# **SUBMISSIONS REPORT**

**SSD - 10831778**

Sydney Children's Hospital Stage 1/  
Children's Comprehensive Cancer  
Centre

**HEALTH ADMINISTRATION CORPORATION**

DRAWING
GENERAL ARRANGEMENT
PLAN L06

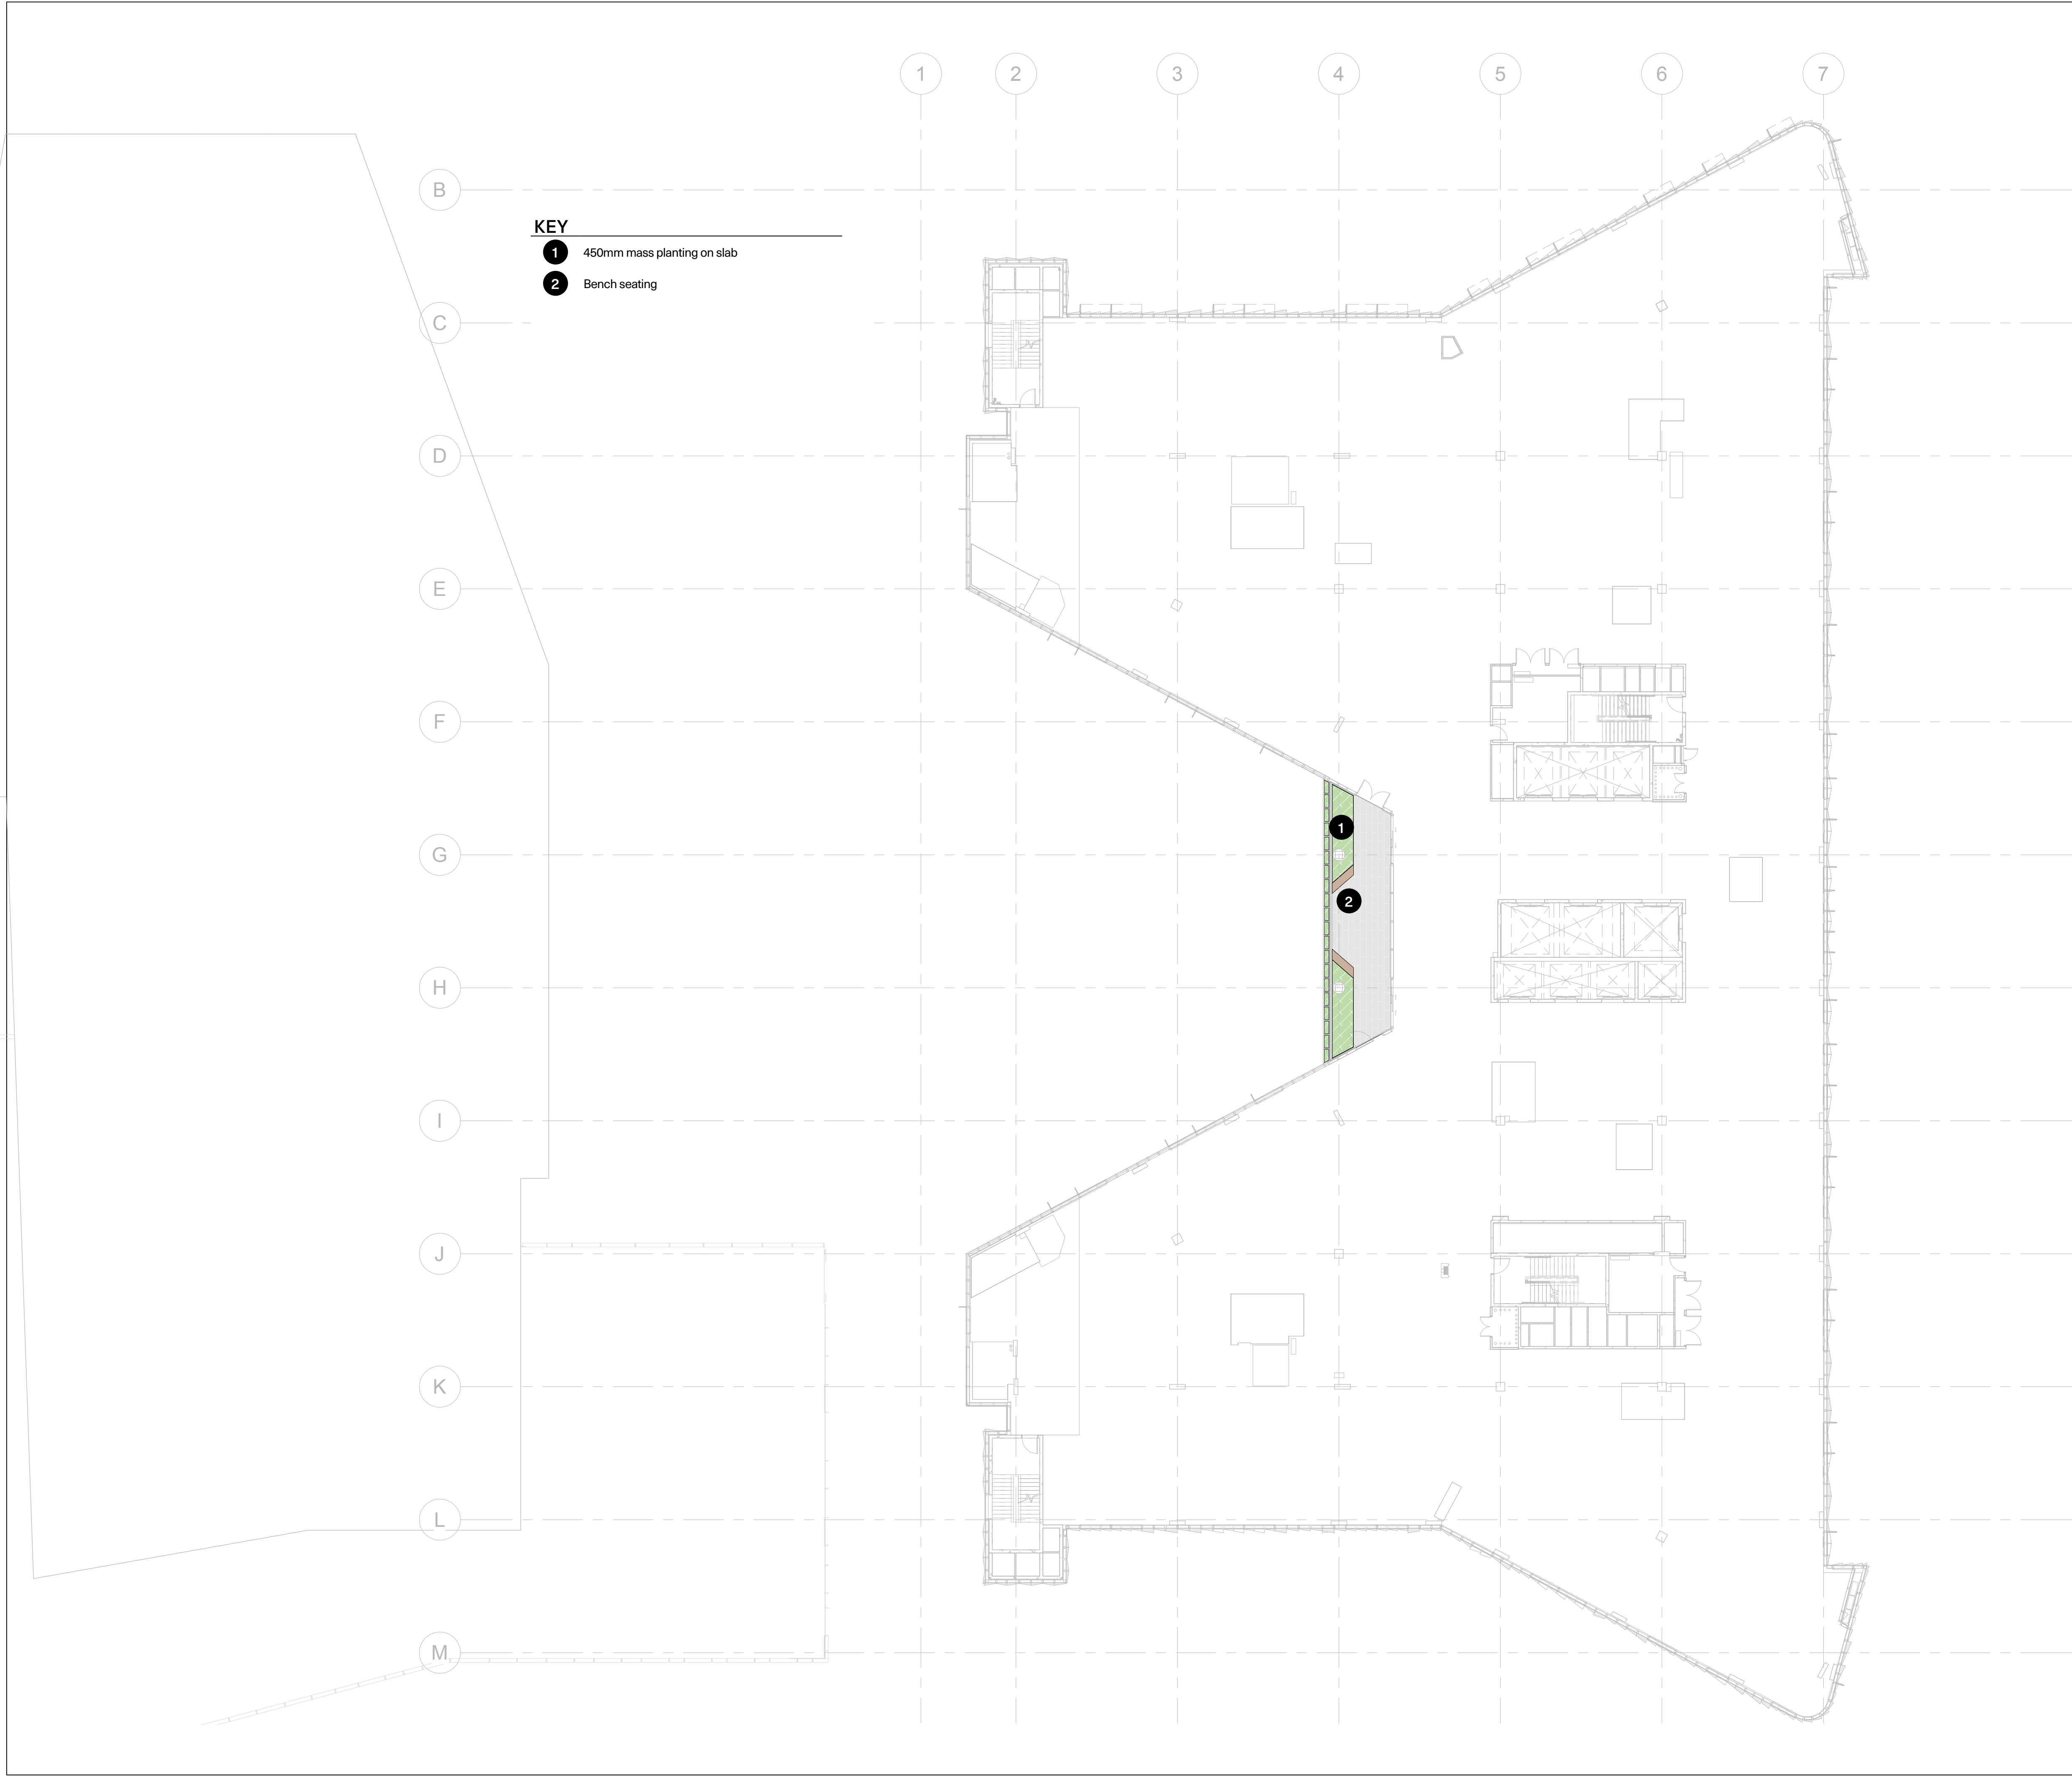
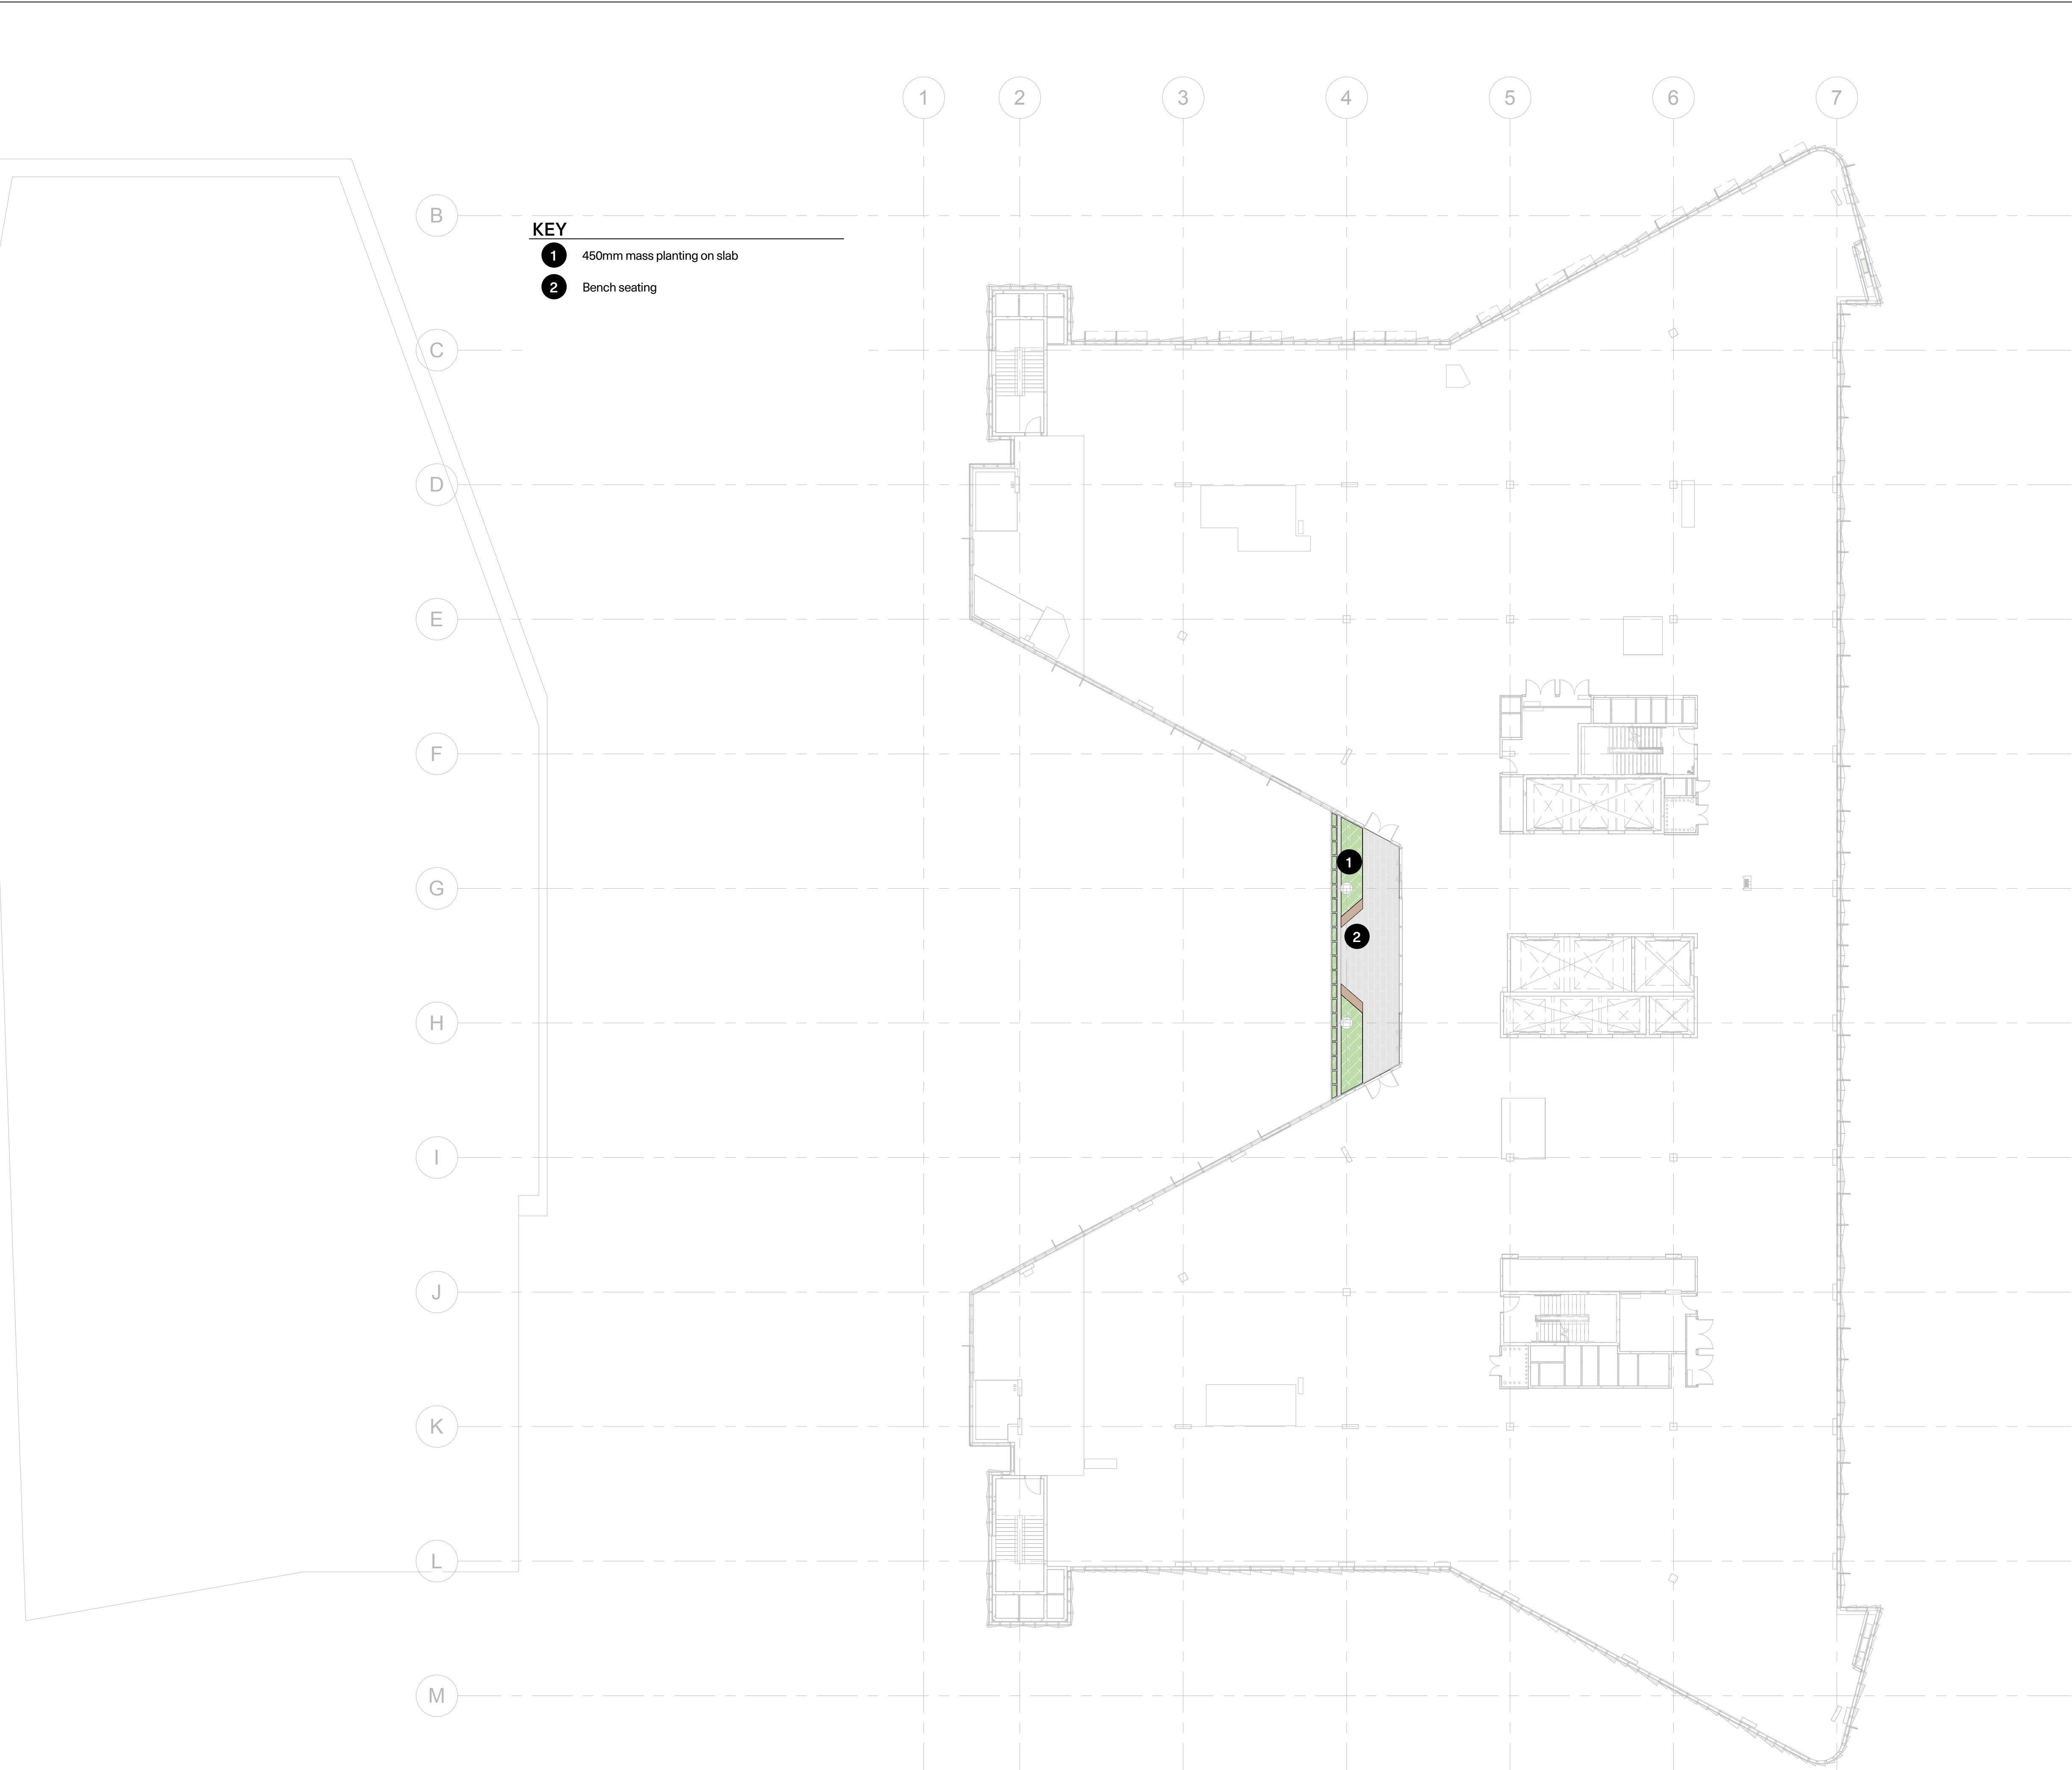
<p>Visualisations indicate landscaping to upper levels terraces and utilisation of podium roof areas for landscaping, but no details are provided on the landscape plans. Landscape plans should be updated to include these areas and demonstrate provision of high-quality outdoor spaces for occupants of the building and to assist with offsetting any shortfall in tree canopy cover.</p>	<p>The amended landscape plans include additional details of proposed landscaping on the upper-level terraces. A series of accessible and inaccessible landscape spaces provide opportunities for patients, staff and visitors to experience the biophilic benefits of being in contact with plants and natural systems on a day-to-day basis. Outdoor space is provided throughout the building with key locations as follows:</p> <p>Level 01 -a northern terrace for patients and families, and an outdoor courtyard for staff is located on the southern side of the building.</p>	<p><b>Appendix E</b></p>

Issue	Referral comment	Response to submission	Reference to information
		<p>Level 04 - two outdoor terraces for staff overlooking the central plaza.</p> <p>Level 06 - an accessible outdoor terrace for patients and families as well as a narrow landscape terrace on the western façade providing a breakout area off the kitchen.</p>	
	<p>Consideration should be given to the design and layout of the landscaped area to the south of the building to create a more legible and direct east-west pedestrian connection between Hospital Road and Botany Street having regard to the alignment of the connection on the HTH site.</p>	<p>The landscape design team has reviewed the design to ensure a generous east-west connection is provided. This was investigated at both the southern and northern existing connection between Hospital Rd and Botany St, however the southern connection adjacent to the IASB building is constrained by the ambulance bay below, and existing levels, making it a poor choice for an intuitive pedestrian route. A minimum 5m DDA-compliant and accessible pedestrian east-west pathway has been created south of the SCH1/CCCC building connecting to the stairs and ramp on the HTH site. This connection will be included as part of the future master plan for the hospital to ensure this connects to a future east-west green spine between Hospital Road and Avoca Street. This pathway is shown in the updated landscape plans.</p>	<b>Appendix C, Appendix E</b>
